13 February 2017  
Ref No. 28777LA2let

**GEOTECHNICAL ASSESSMENT**  
**PROPOSED MODIFICATION 14 WORKS**  
**THE STAR, 80 PYRMONT STREET**  
**PYRMONT, NSW**

Further to your request on 9 February 2017, we have reviewed the supplied preliminary architectural drawings prepared by DWP Suturs (Project No. 303457, Drawing Nos. MOD14-A10B1<sup>C</sup>, MOD14-A10B2<sup>C</sup>, MOD14-A10B3<sup>B</sup>, MOD14-A10B4<sup>B</sup>). From a geotechnical perspective, we understand that the proposed development comprises:

Drawing Number
MOD14-A10B4

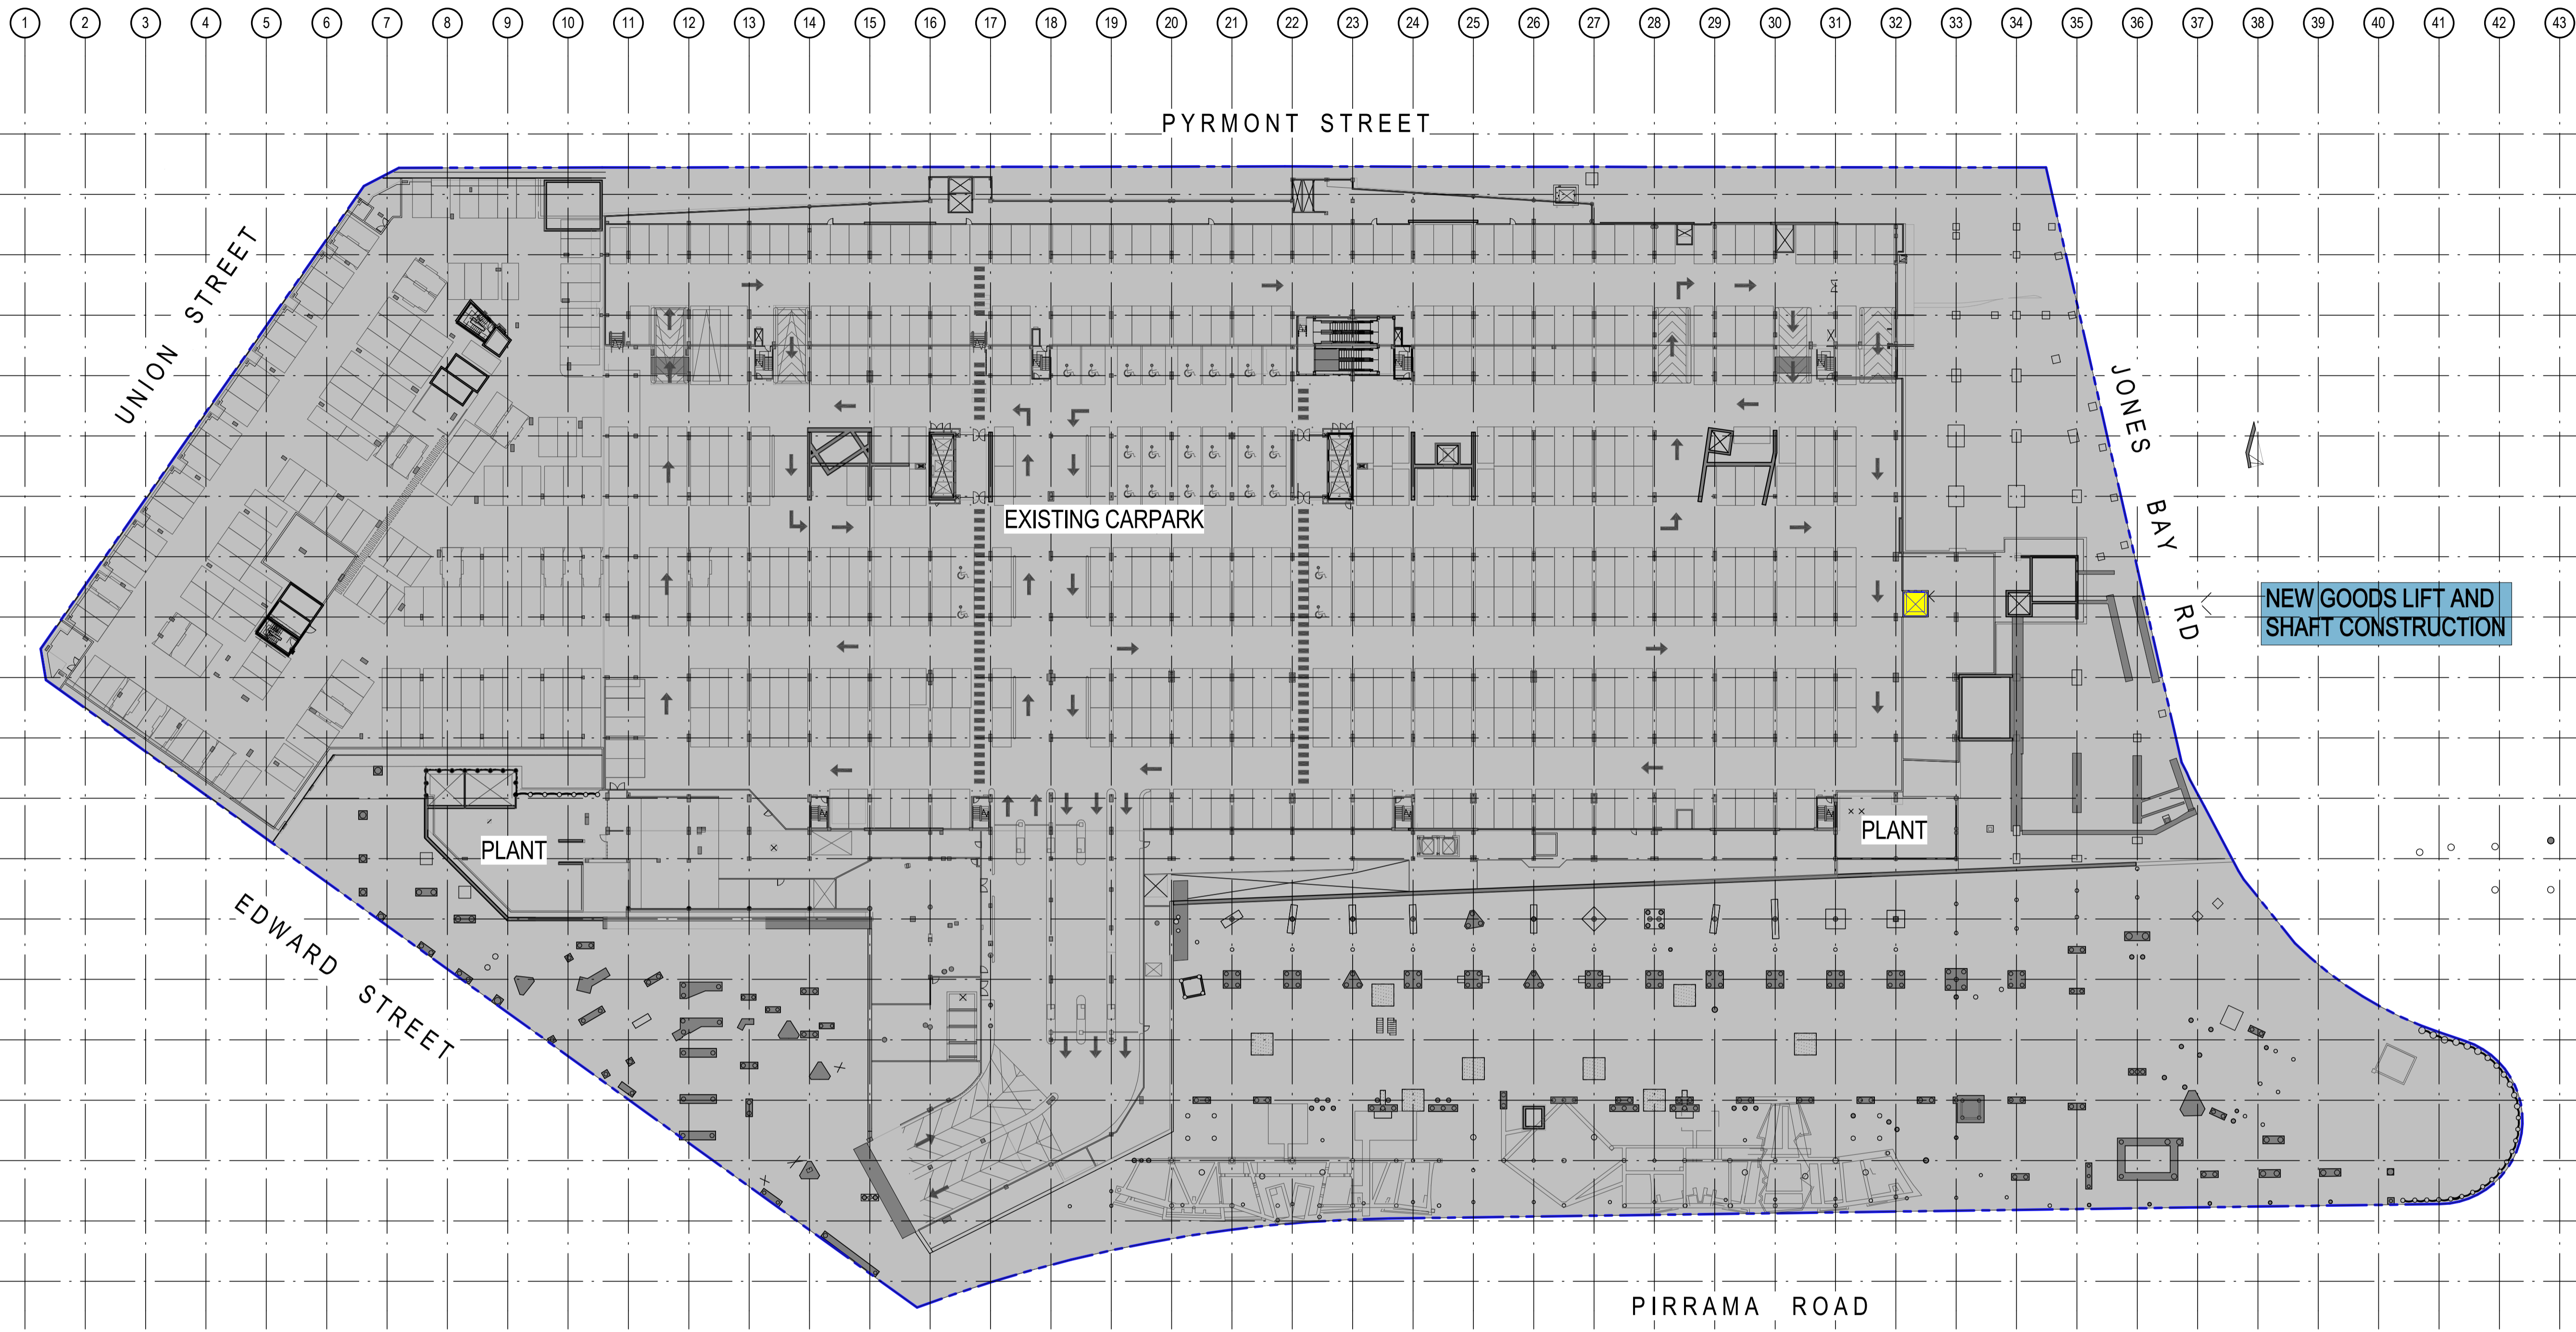
- Construction of a lift between Levels B01 and B04, adjacent to Grid Lines J/32. We have assumed that the lift over-run pit will require excavation to a maximum depth of 2m below Level B04. The lift pit will be exposed on the northern side of the lower Level B05 car park.
- An infrastructure upgrade on Level B02, between Grid Lines J & N and Grid Lines 34 & 37. Additional loads will be placed on existing columns and footings.
- Installation of new diesel fuel storage tanks and a new stormwater pump and filter on Level B04, between Grid Lines K & N, and Grid Lines 33 & 35. These facilities will be installed immediately outside the developed Level B04 footprint (below the B03 slab) and will require minor excavation into the existing basement cut profile.

Based on the results of our assessment, we expect that the proposed lift pit excavation (below Level B04) will extend into sandstone bedrock, and into the cut face exposed along the northern side of the lower Level B05. The minor excavations for the installation of the new diesel fuel storage tanks, stormwater pump and filter on Level B04 are expected to extend into existing granular fill and sandstone bedrock.

Due to the limited site access, the soil and rock excavation will most likely need to be carried out using hand equipment; for example, shovels and jackhammers. Grid sawing the surface of the bedrock with a concrete saw would facilitate removal of the sandstone when using jackhammers. Dust suppression by spraying with water should be carried out whenever concrete saws are being used.

Excavations through granular soils should be temporarily battered back at no steeper than 1 Vertical (V) on 1.5 Horizontal (H) on condition that surcharge loads are kept well clear of the crests. Once the structural design has been completed, further advice should be sought with respect to the long-term retention detail; that is, permanent batter slopes and/or retaining walls.

We expect that good quality, medium strength and stronger sandstone (without adverse defects) can be cut vertically. Notwithstanding, all vertically cut rock faces must be inspected by an experienced geotechnical engineer on completion of excavation to identify features which may require stabilisation (eg. underpinning, rock bolting and/or shotcrete and mesh). Provision must be made in the construction program and budget for the inspections and stabilisation works. As the dowels and rock bolts will be
